Review of County Council's Response to Consultation

Planning Application No. 17/02534/OUT-2

**Land North of Bicester Avenue, Garden Centre, Oxford Road,
Bicester**

Cherwell District Council

### Proposed Junction Mitigation

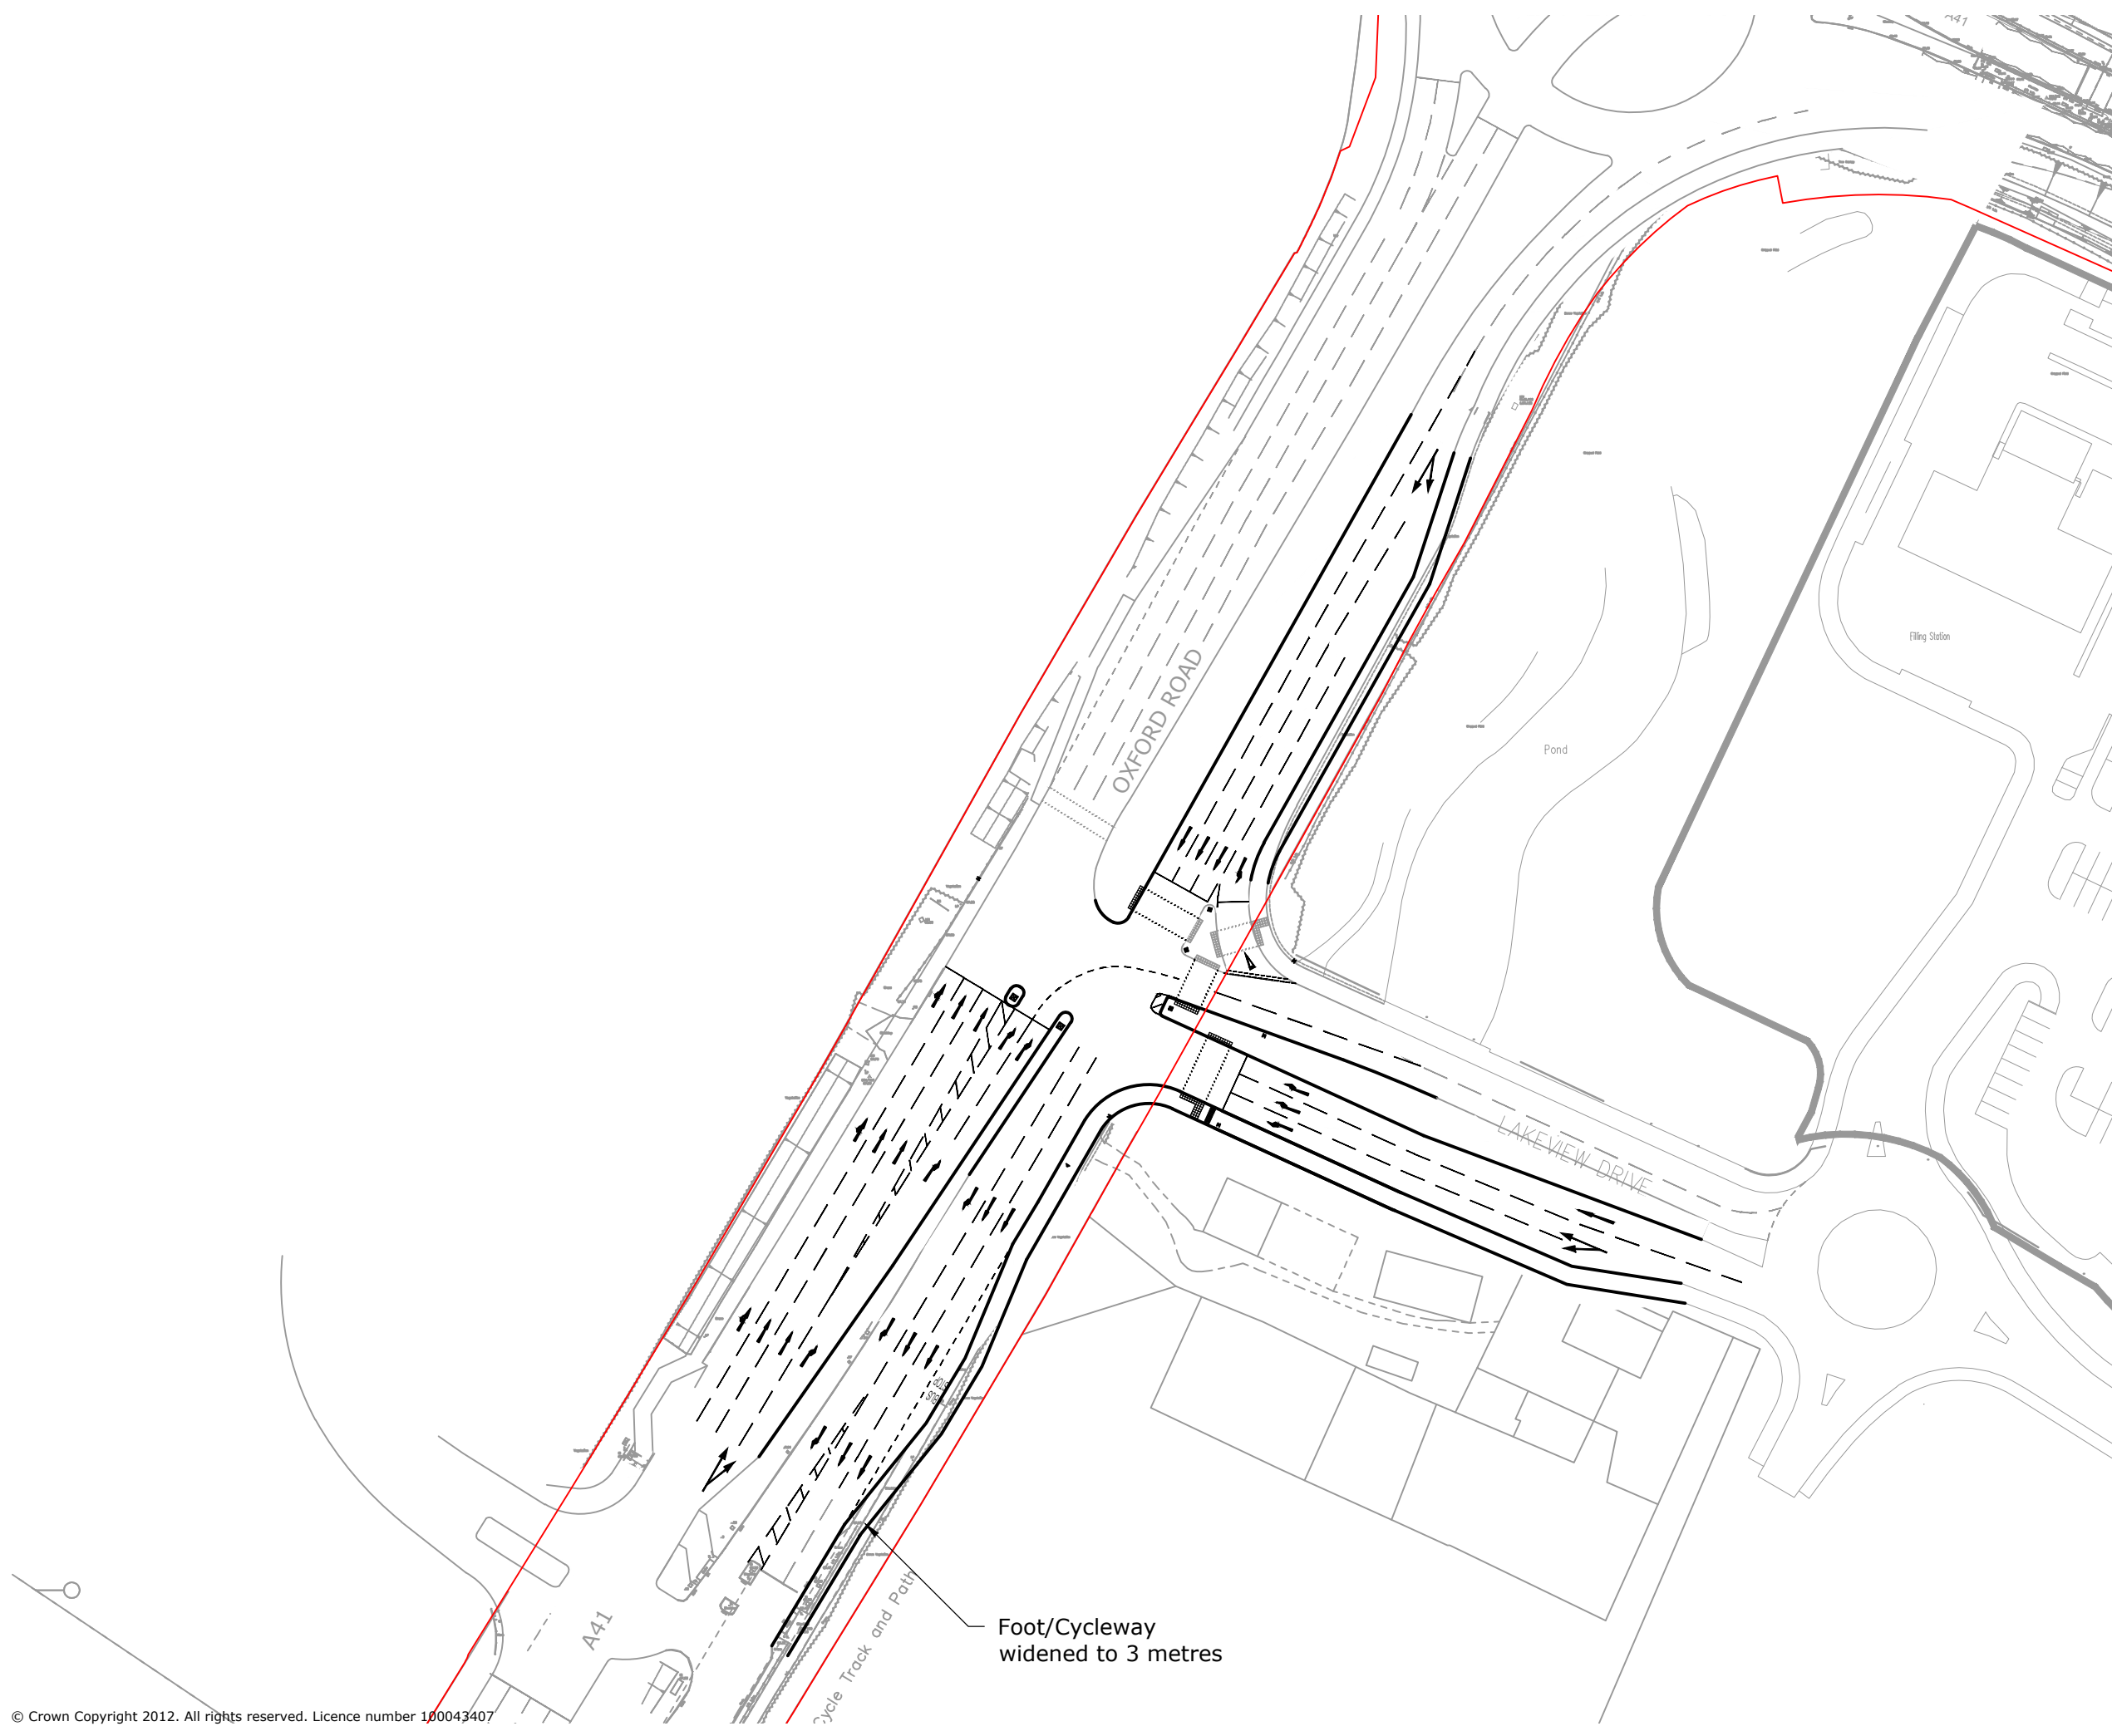
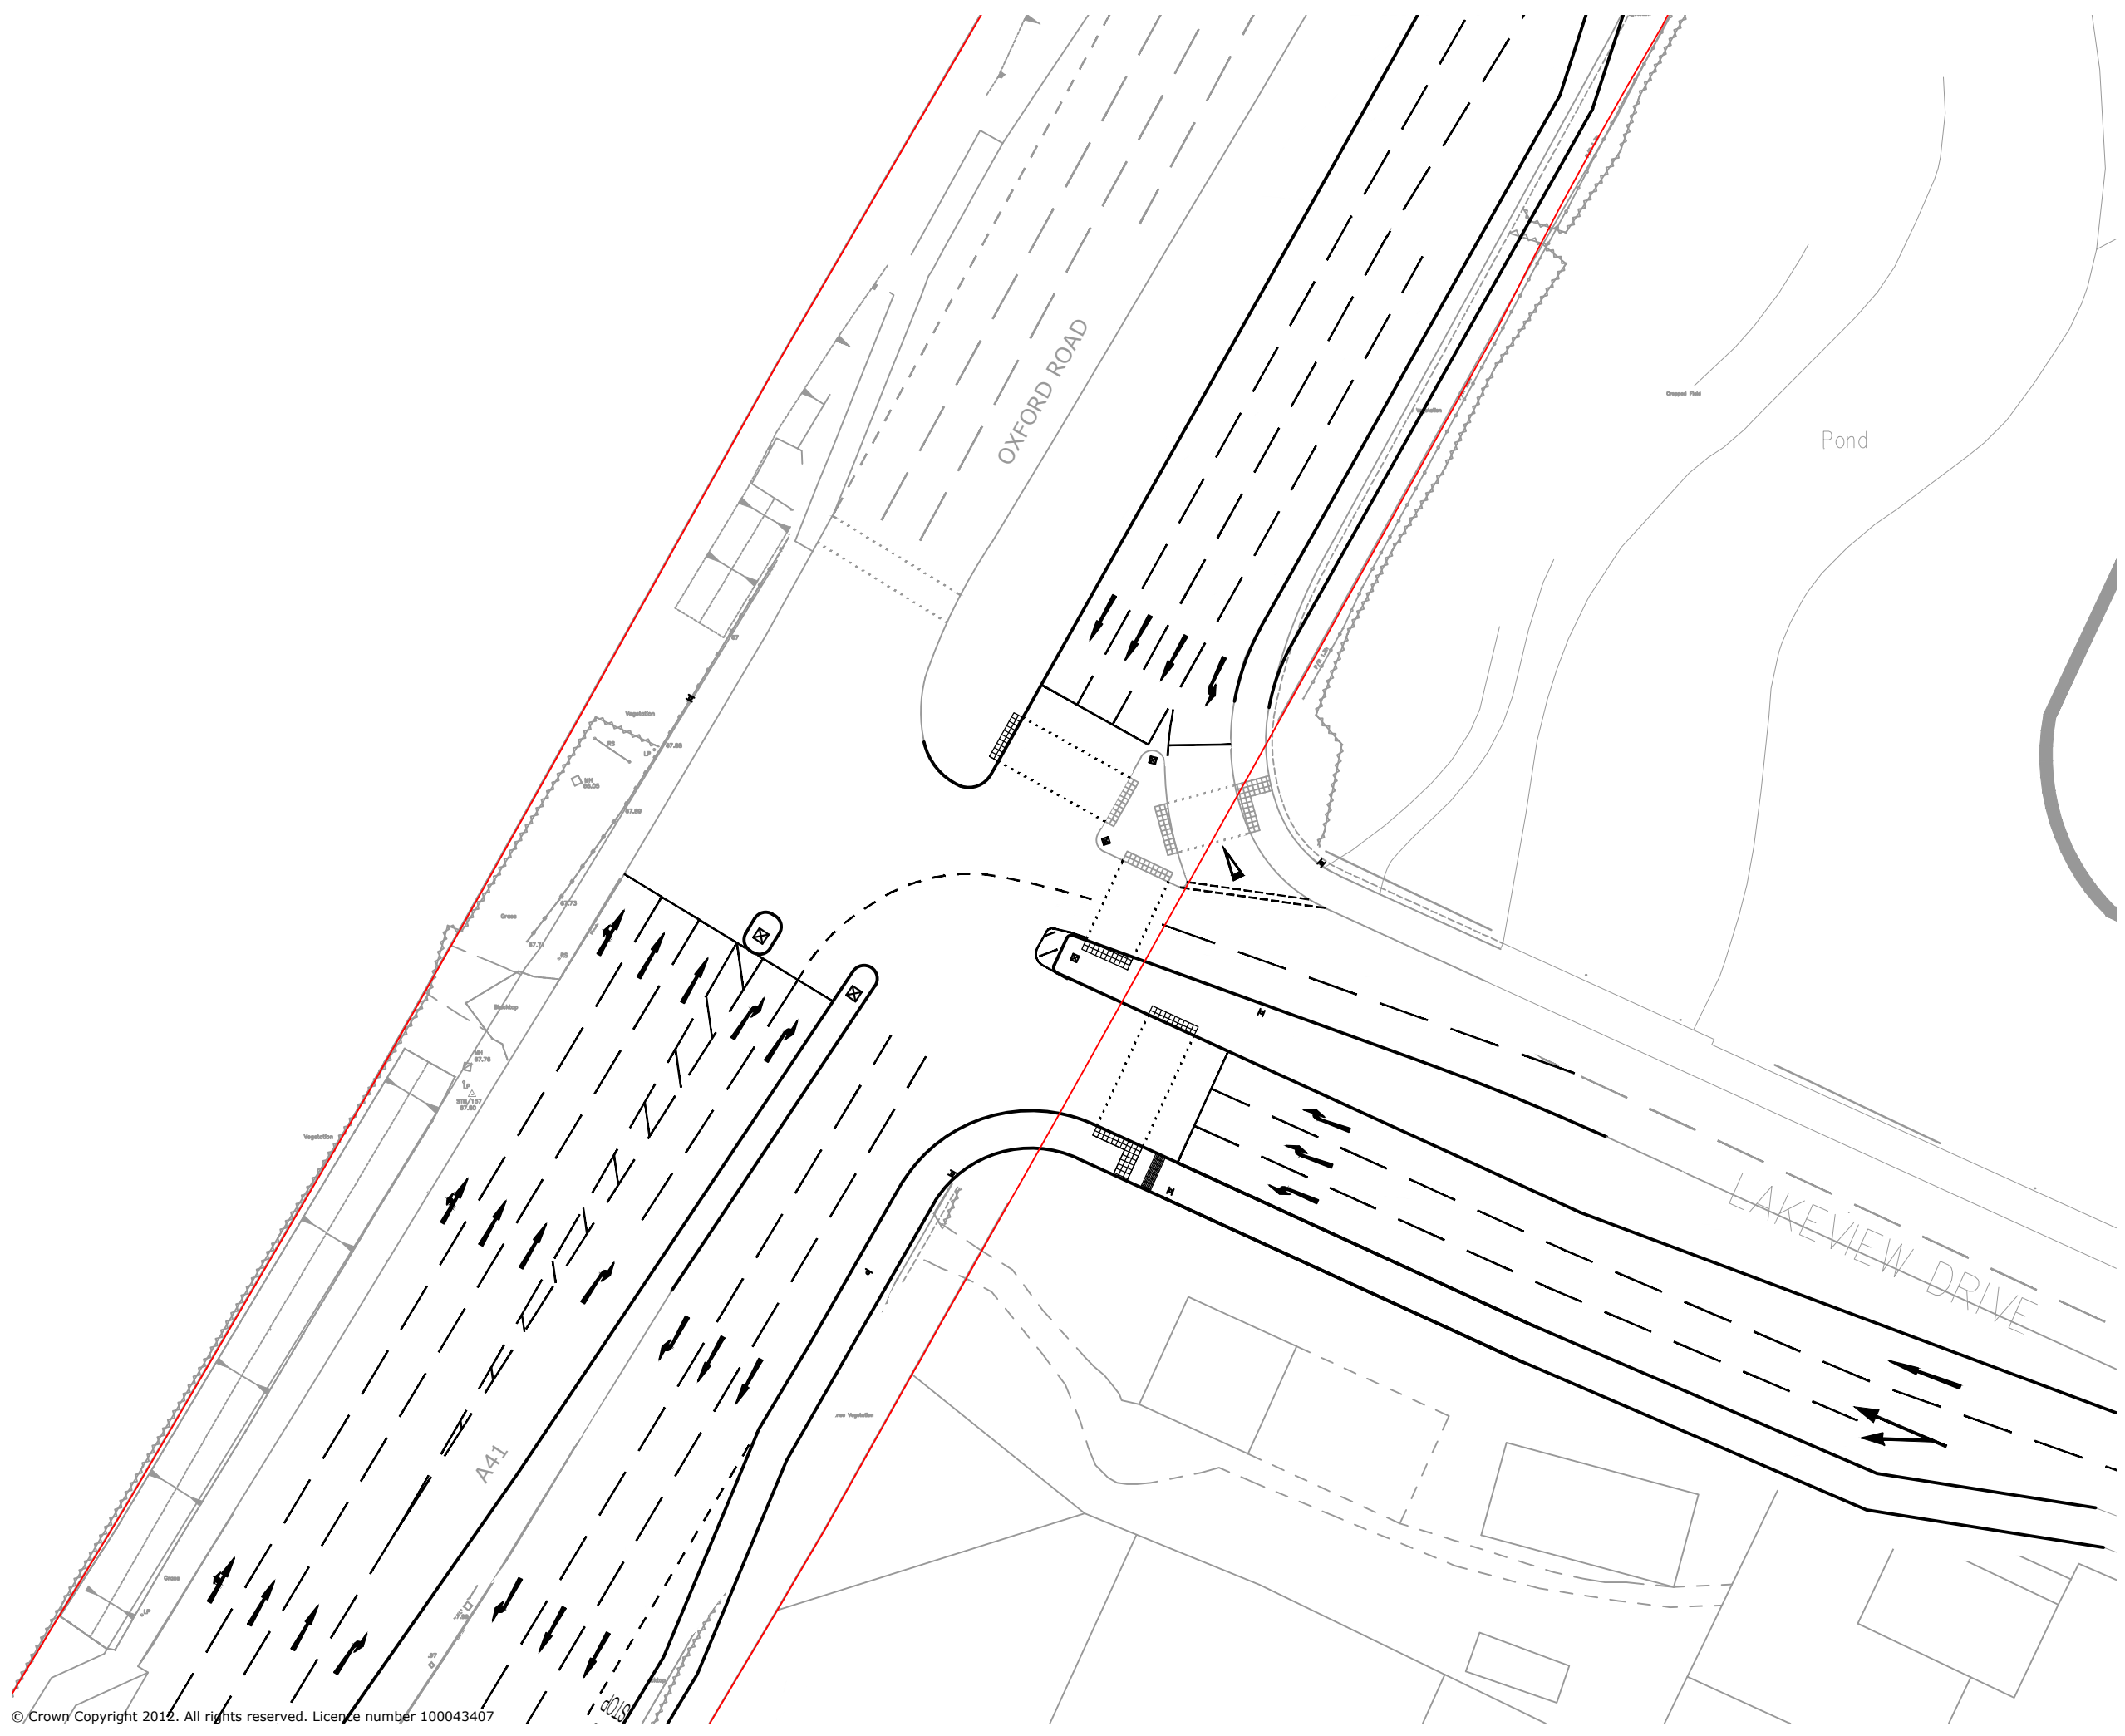
- 3.11 OCC believe the proposed development would have a detrimental impact on the existing network which has not been adequately mitigated. OCC are concerned that even with the proposed mitigation the analysis shows queues on Lakeview Drive reaching 42 vehicles. OCC consider that the storage capacity between the junction and the Tesco roundabout is approximately 15 vehicles which would effectively result in traffic adversely affecting the performance of the Tesco roundabout junction and the ability of traffic being able to egress the Tesco car park. OCC also contend that if vehicles are unable to exit Tesco 'it is likely that traffic within the site would back up to the extent that vehicles would not be able to get in, with the risk that queueing traffic would back up onto the A41'.

- 3.12 OCC also consider that on Lakeview Drive '... Very substantial delays could also be detrimental to road safety as they may well lead to unsafe manoeuvres by impatient drivers.'

- 3.13 In considering OCC's concerns I would suggest that its worth bearing in mind:
- a. The LinSig analysis is for the AM and PM peak hours only;
 - b. The base scenario (see Table 1 above) already produces a queue of 21 on Lakeview Drive which is more than the 15 referred to by OCC so the matter of blocking the Tesco roundabout will already be an issue during the PM peak hour.

- c. The LinSlig analysis does not take account of the benefits of MOVA
 - d. The access drive serving the Tesco car park has a very long two-way drive so even if there was a queue during the PM within the car park waiting to egress I doubt whether this would adversely affect the ability of drivers being able to access the car parking spaces.

- b) Notwithstanding a) above, that LinSig analysis reveals that the DoS deteriorates with three lanes exceeding 90%. This is likely to mean that these lanes will be sensitive to future increases in traffic or variations in traffic volume leading to disproportional increases in queues and delays. This is a matter, I'll return to on the section entitled 'Planning Obligations'.

- c) Whilst respecting OCC's concern about the impact on Lakeview Drive I am of the view that Lakeview Drive is a private road and as such unless the operation of the private road affects the public highway this is not necessarily a matter for the highway authority.

- d) I refer to OCC's concern about substantial delays on Lakeview Drive being detrimental to road safety due to the possibility this may lead to unsafe manoeuvres by impatient drivers. With respect to OCC, I regard this as unsubstantiated speculation unless there is reasonable evidence available that can be used to support this assertion.

- e) As alluded to in 3.9(d) above the access drive serving the Tesco car park is two-way and provides plenty of internal storage capacity so, from the information provided, I find it difficult to share OCC's concern that traffic within the site would back up to the extent that vehicles would not be able to get in, with the risk that queueing traffic would back up onto the A41.

3.15 In summary and bearing in mind that the Stage 1 Road Safety Audit raises no objections to the design, in principle, I consider the proposed mitigation to be acceptable subject to:

- a) S106 obligations being agreed (see below);
- b) The LinSig models being updated (see para. 3.3) to validate my views about the proposed mitigation being acceptable.
